St Anthony of Padua Catholic School Redevelopment (SSD-8865)
Request for Additional Information

I refer to Response to Submissions (RtS) for the St Anthony of Padua Catholic School Redevelopment (SSD-8865). After careful consideration, the Department is requesting that you submit additional information that effectively addresses the issues identified in **Attachment 1**.

1 DIAGRAM - STAGING 3
1 : 1000

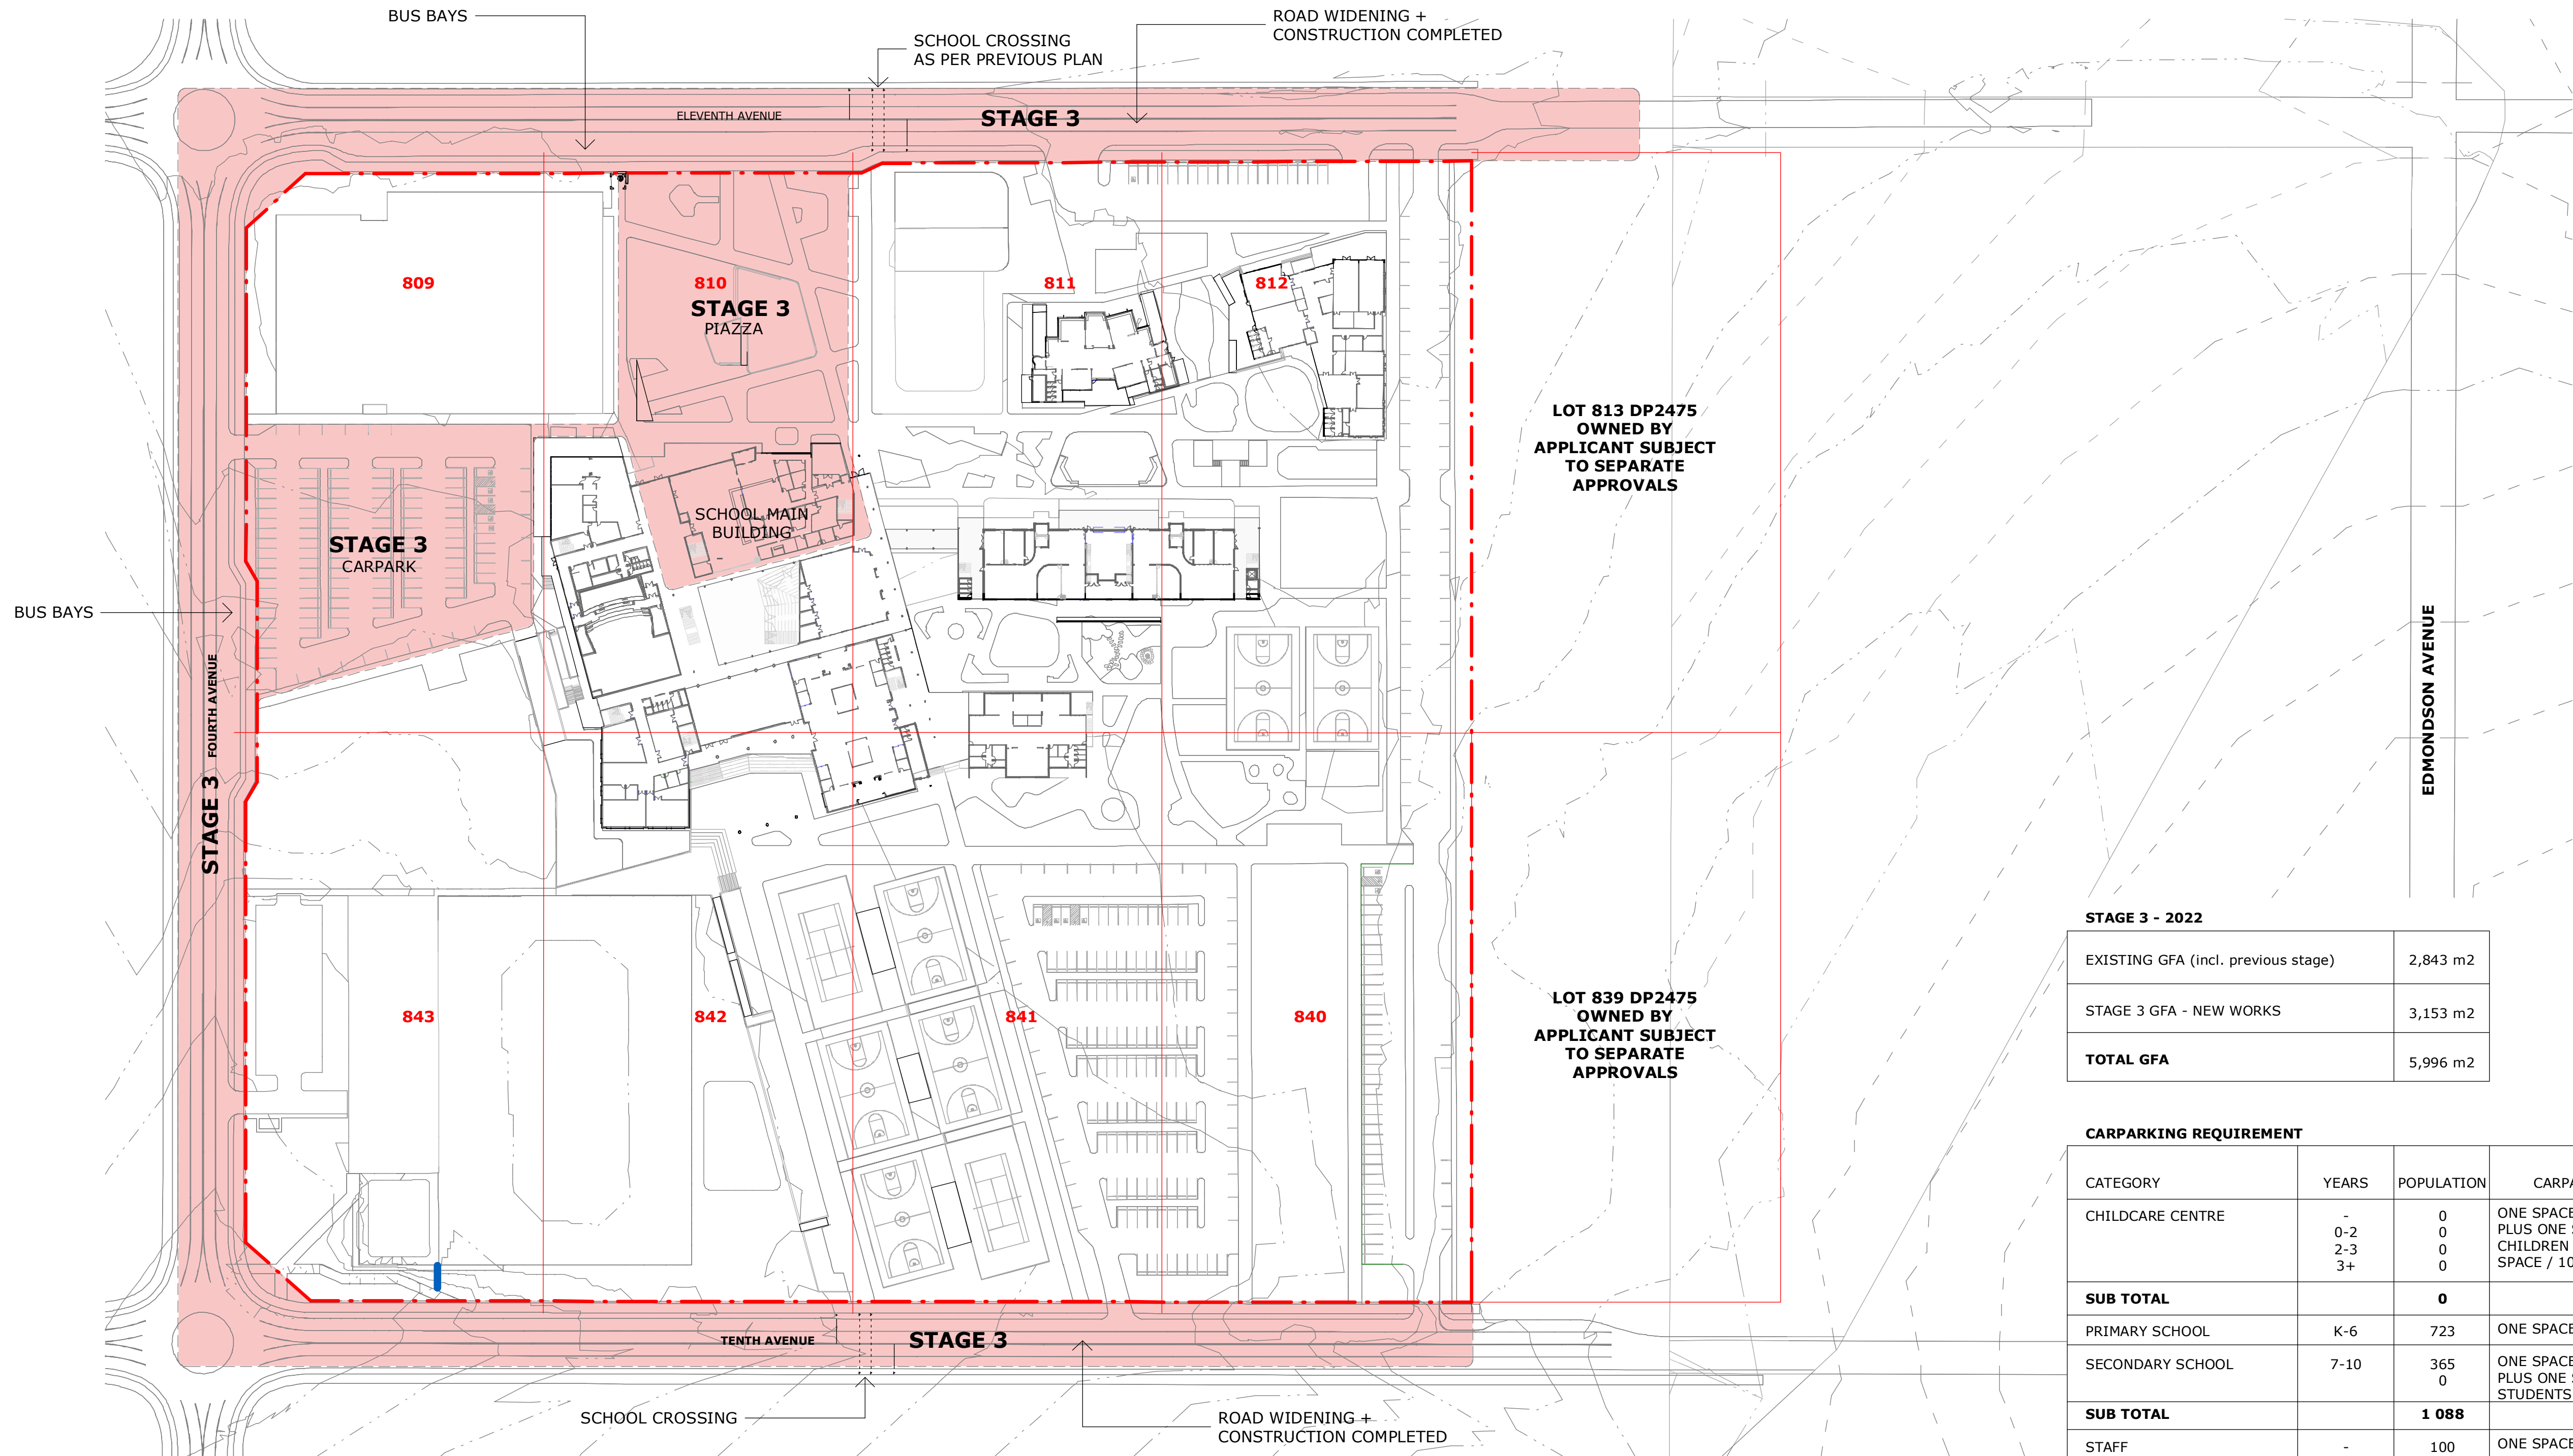
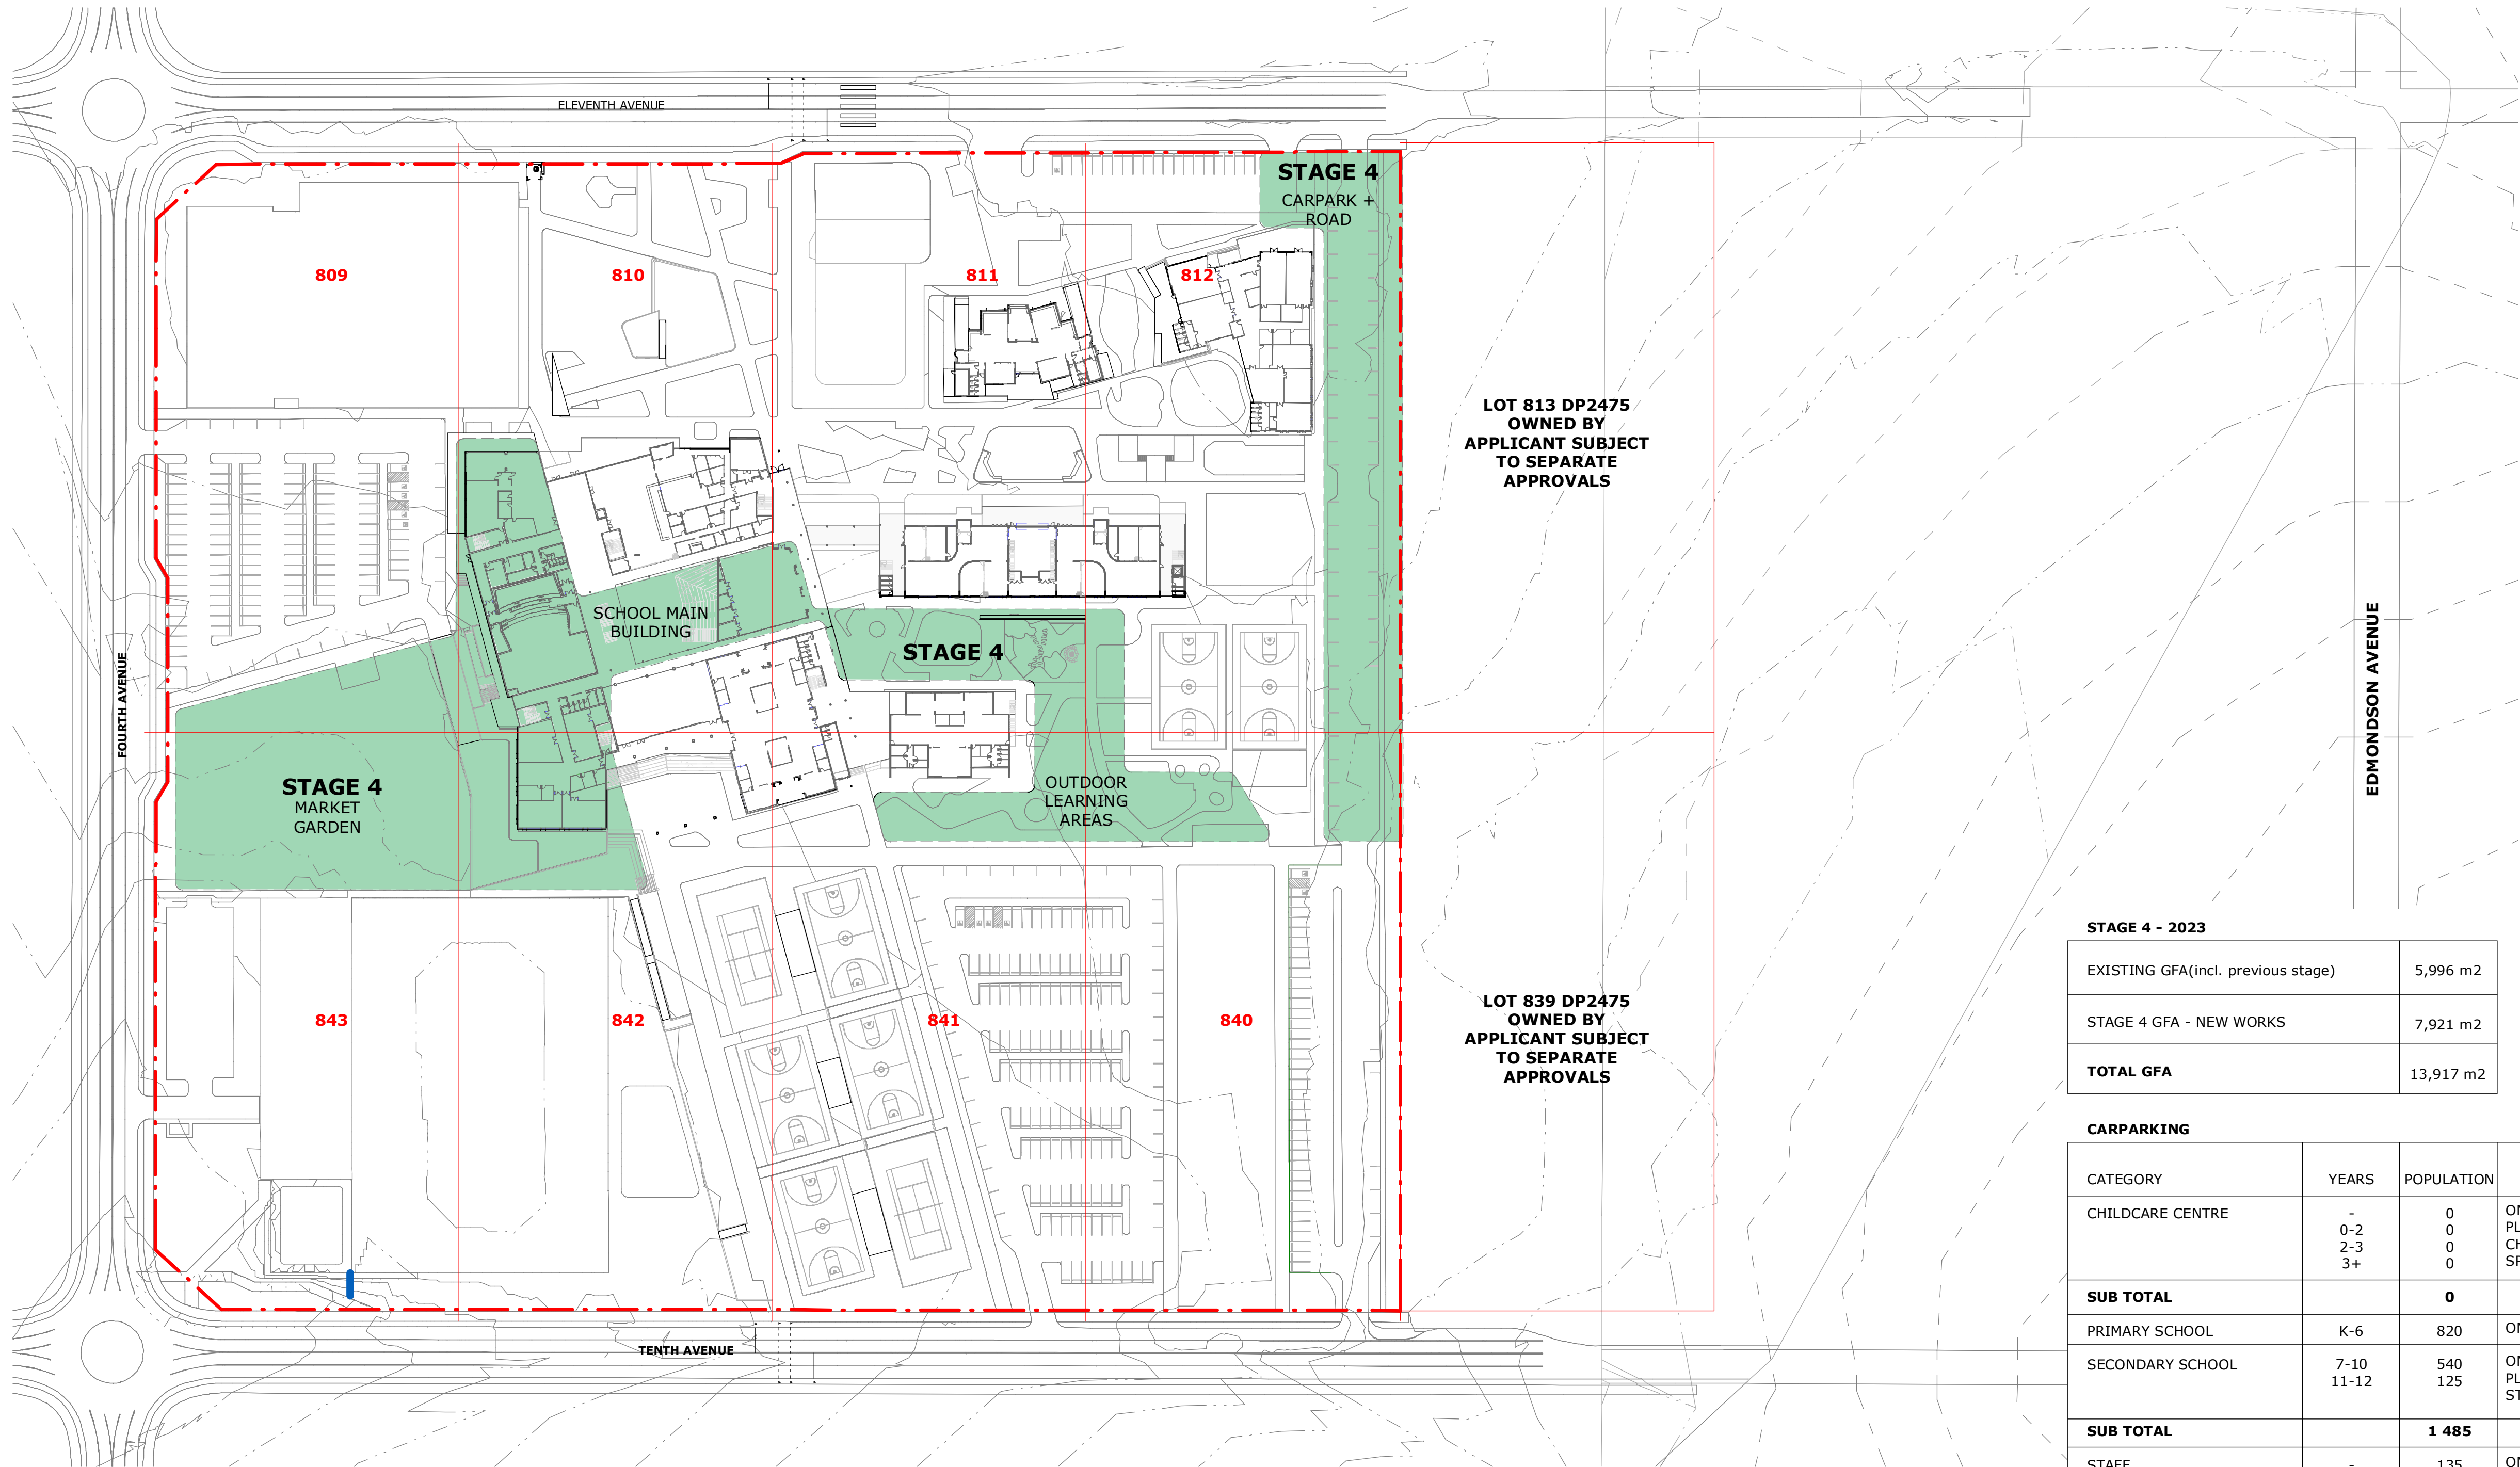
- a single (integrated) staging plan should be submitted that includes all construction stages in one plan.

- the central section of the eastern drop-off and pick-up area (on the internal road) and landscaping to the east of the central hub building have not been included in any of the construction stages. The Staging plans should be amended to include these works.

- the staging plans do not clarify whether the demolition works / remediation works tree removal would be undertaken prior to any works on the site or whether these works would also be undertaken in stages. Should these works be undertaken in stages, the following matters are required to be separately justified:

- the gross-floor area for each construction stage.
 - The correct number of car parking and drop-off and pick-up spaces for construction Stage 4 noting that the existing information is incorrect (177 car spaces) as it does not include the proposed 22 drop-off and pick-up spaces.
